88 Waterloo Road Development

Response to Submissions (Architecture & Urban Design)

This report has been prepared in response to the Department of Planning, Housing and Infrastructure's ('DPHI') request for a Response to Submissions ('RtS') for the proposed mixed-use development at 15–21 Cottonwood Crescent, Macquarie Park ('88 Waterloo').

ELOUERA RESERVE INTERFACE

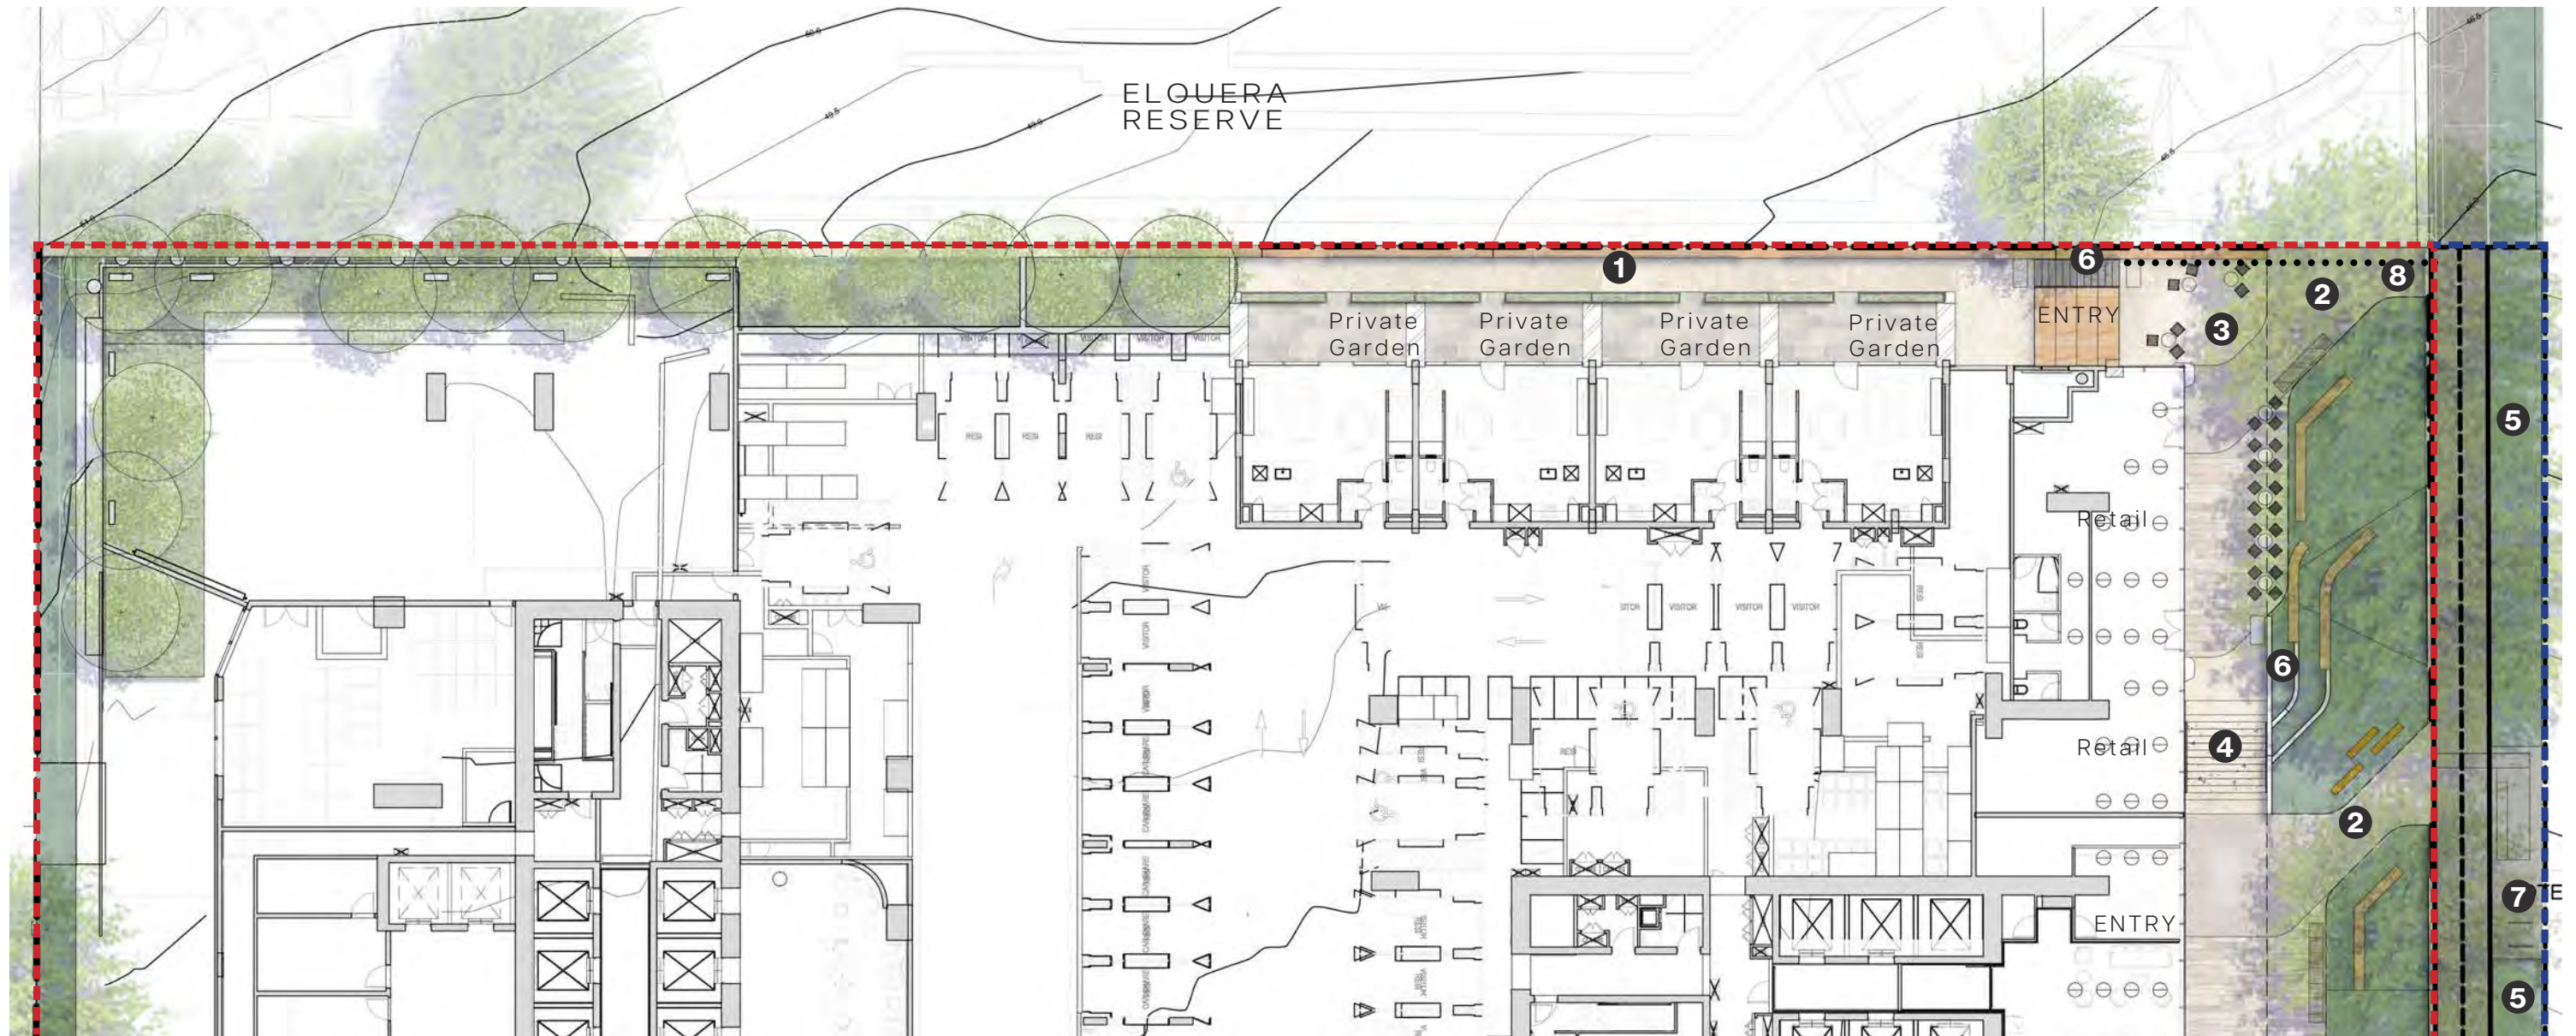
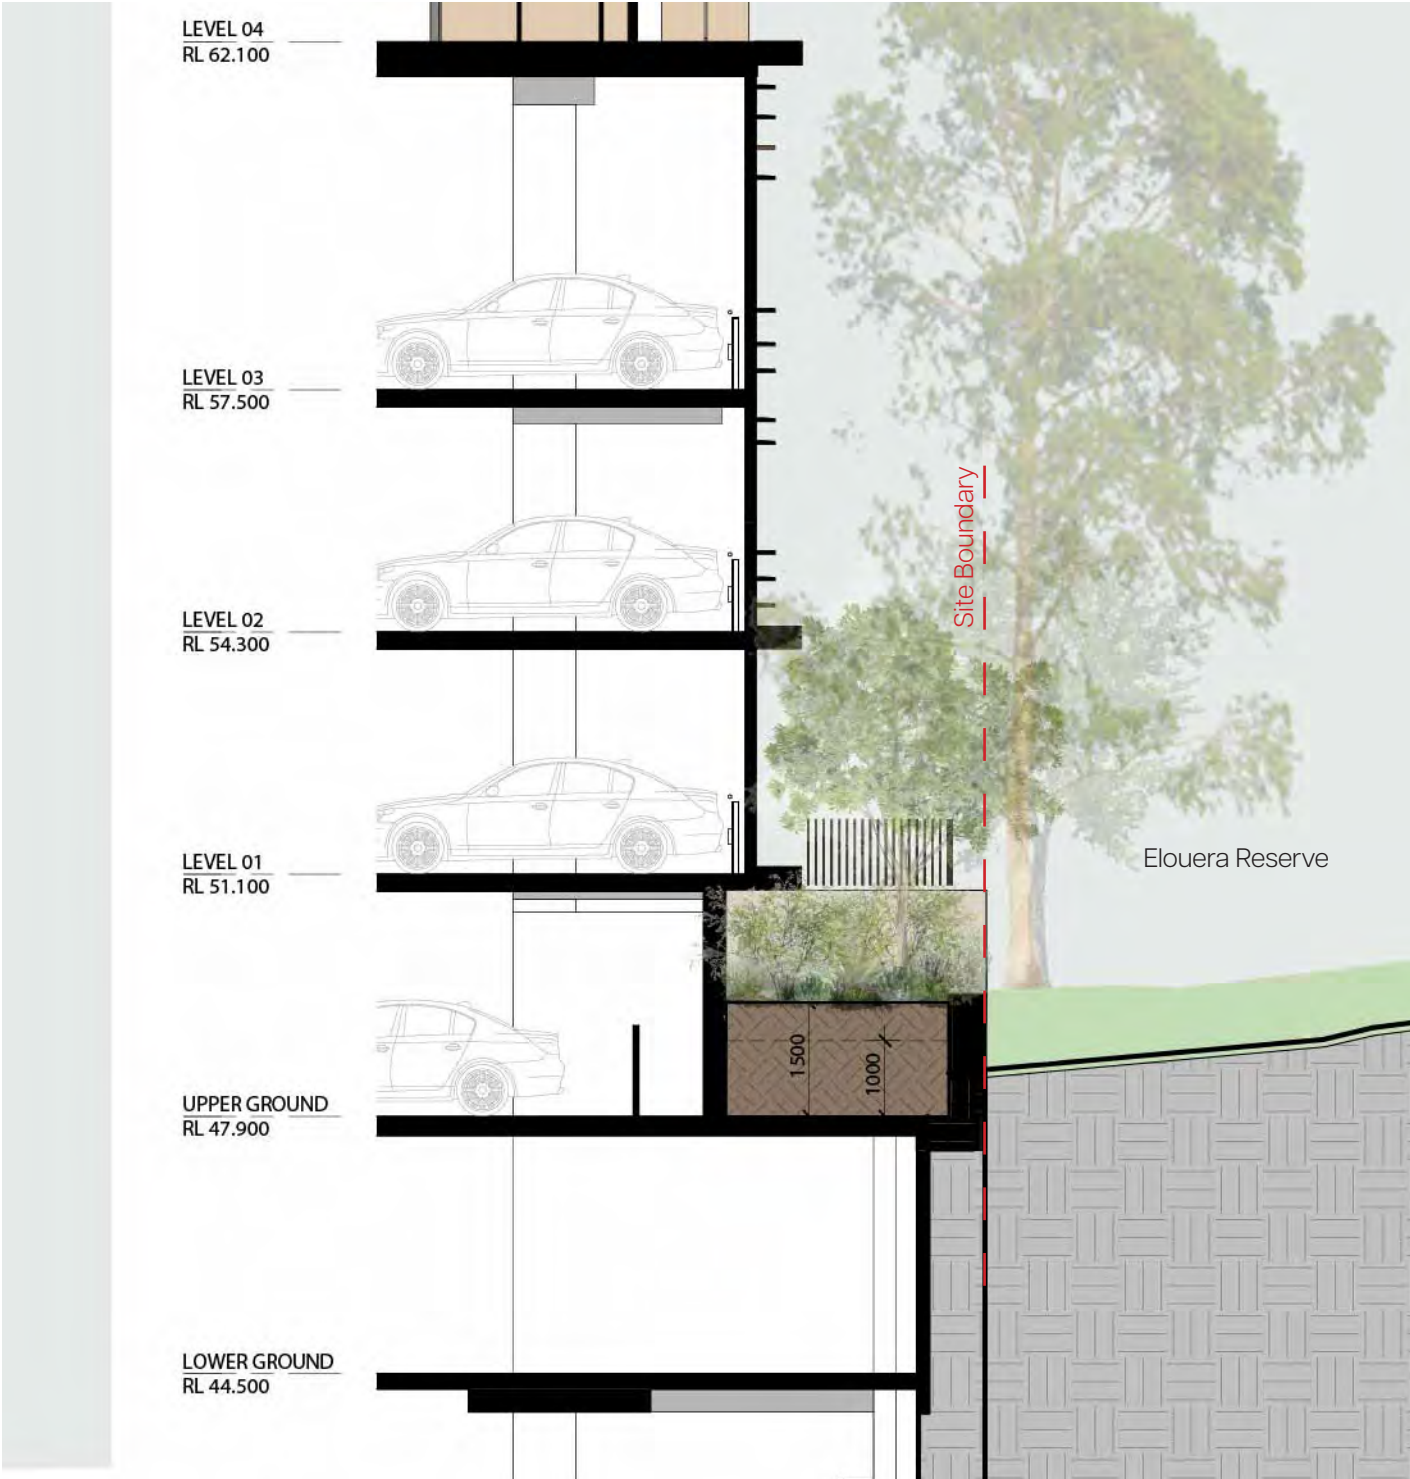
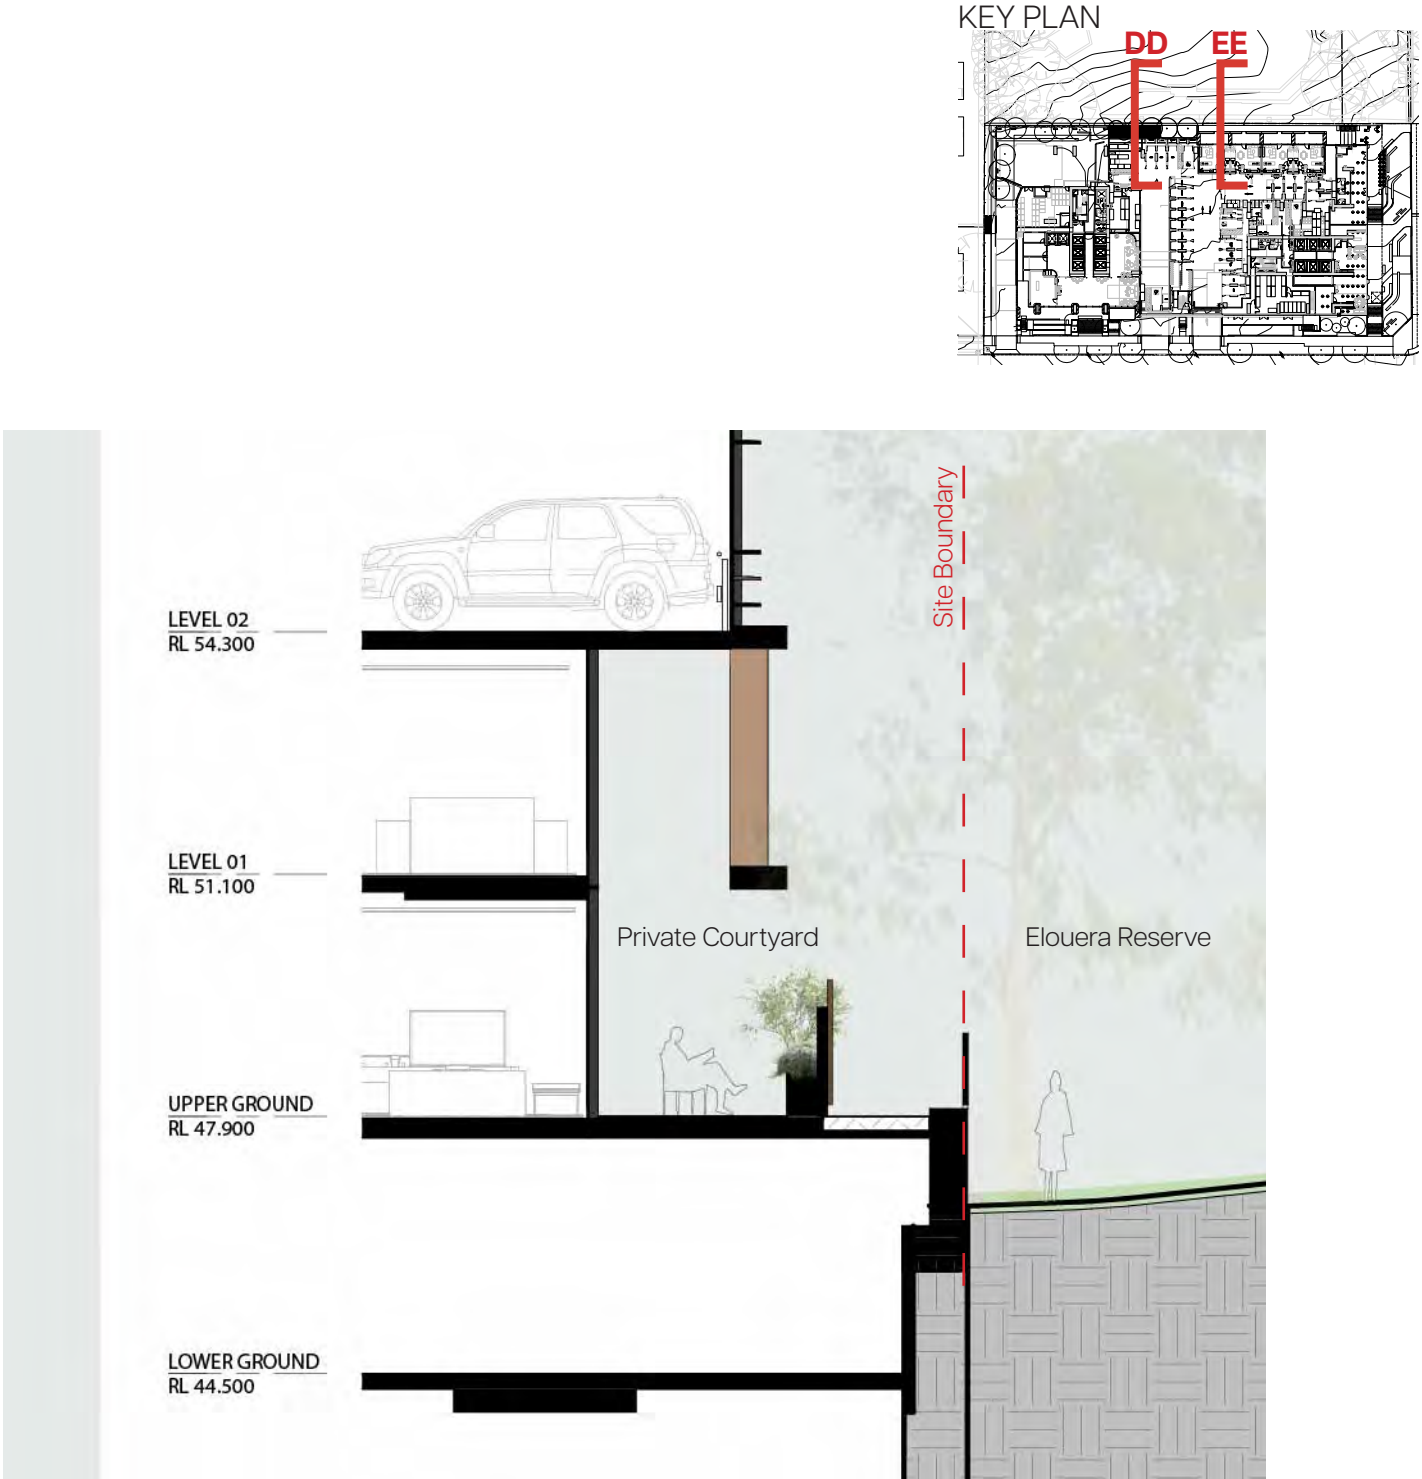
"The proposal's podium interface with Elouera Reserve is suboptimal due to limited setbacks and four levels of car park screening across approximately half of the frontage. While three trees are proposed along this boundary to offset the visual bulk of the podium, their establishment and growth would be constrained by the podium two storeys above and basement parking below. The podium setback to Elouera Reserve must be increased to facilitate tree retention, additional tree planting, improved building interface and reduce perceived bulk."

The site is positioned within the Metro Line's 'Second Reserve', increasing the cost of basement excavation. The above ground podium allows for more dwellings to be provided within this constraint. Increasing the setback of the entire podium - to create an area for trees - is not possible without losing a level of parking that makes the efficiency of above-ground parking unfeasible to deliver.
